SUMMARY MEMORANDUM

TO: El Paso County Board of County Commissioners
FROM: Planning & Community Development
DATE: 5/28/2026
RE: SP251; Antler Range Preliminary Plan

A request by Antler Rancge, LLC for approval of a 244.496-acre Preliminary Plan illustrating 84 single-family residential lots, 1 tract, and 21.982 acres of right-of-way dedication. The property is zoned RR-2.5 (Residential Rural) and is located at the northeast corner of the intersection of Meridian Road and Ayer Road. Water sufficiency for water quality, quantity, and dependability is requested. (Parcel No. 4218000022) (Commissioner District No. 1)

ANTLER RANGE PRELIMINARY PLAN

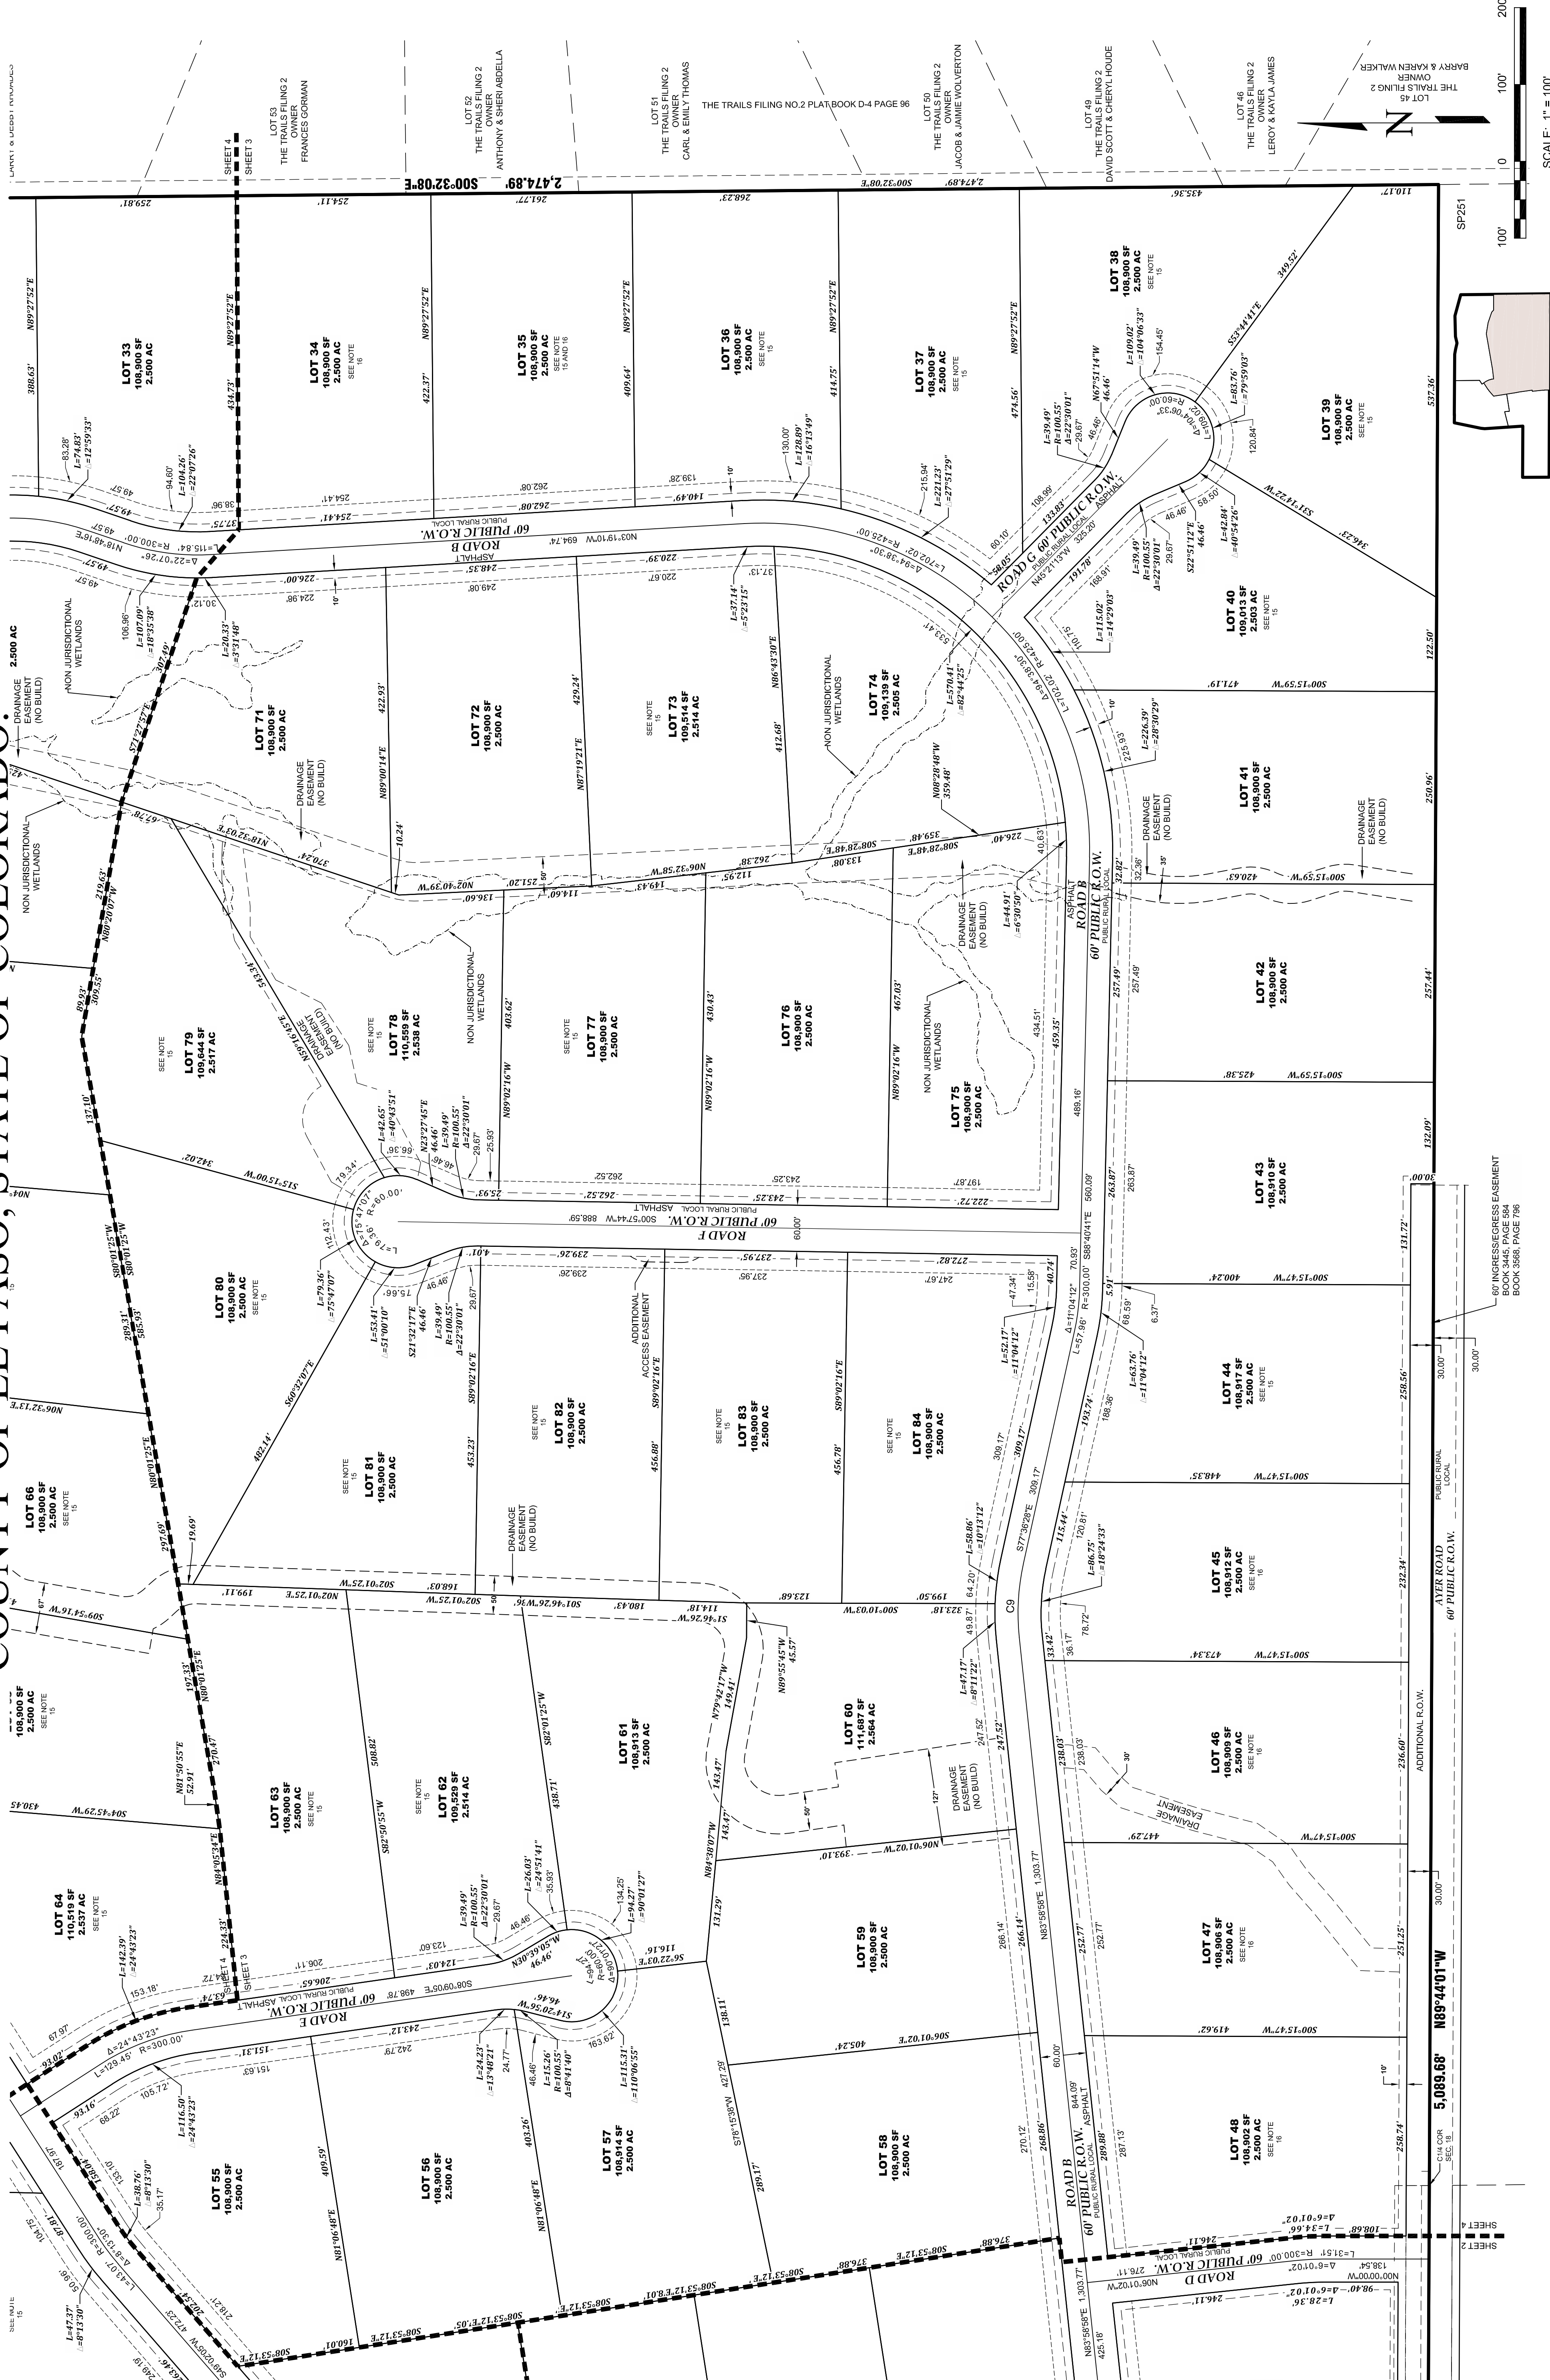
Mr. Carlson inquired about access to lots 6, 7, 8, and 9 to and from Ayer Road. The applicant agreed to change note no. 17 as depicted on the Preliminary Plan to allow access to the four lots. Mr. Trowbridge requested clarification that Ayer Road would be paved. Ms. Dossey replied that Ayer Road will be built to County Road standards. Mr. LeRoy, in opposition, spoke to the additional vehicular trips in the local area. He stated he had provided alternative subdivision designs to the applicant that would remove the increased traffic from Ayer Road as proposed. Ms. Dossey responded, stating that the alternative design did not reduce the number of vehicular trips to the area and required the crossing of a floodplain, which was not in the applicant's best interest.

Mr. Carlson questioned whether General Note 17 on the preliminary plan, which states there will be no direct lot access to Meridian or Ayre Road, conflicted with the proposed access arrangement for Lots 6, 7, and 8. **Mr. Kilgore** confirmed that revisions to the plat note would be necessary to reflect the shared access proposed for those lots. **Ms. Dossey** further explained that, based on the roadway

Mr. LaForce confirmed that, based on the roadway classification criteria, direct access onto Ayre Road is permitted for the four identified lots. He stated that Staff intended to revise the plat note to clarify that no direct lot access would be permitted except for those four lots, in an effort to minimize the number of access points along the roadway and encourage the remaining lots to take access from the internal local roads. **Mr. LaForce** also addressed prior concerns regarding the large loop roadway design and explained that Staff had worked with the applicant to revise the original layout. He noted that the initial design aligned directly opposite an existing intersection along Ayre Road, which created concerns regarding a single point of access. The revised configuration shifted the access points to provide multiple means of ingress and egress in the event one access point becomes blocked. He further stated that the westernmost access point meets intersection spacing requirements, while the eastern access point required approval of a deviation request, though Staff determined sufficient separation still exists between the two intersections.
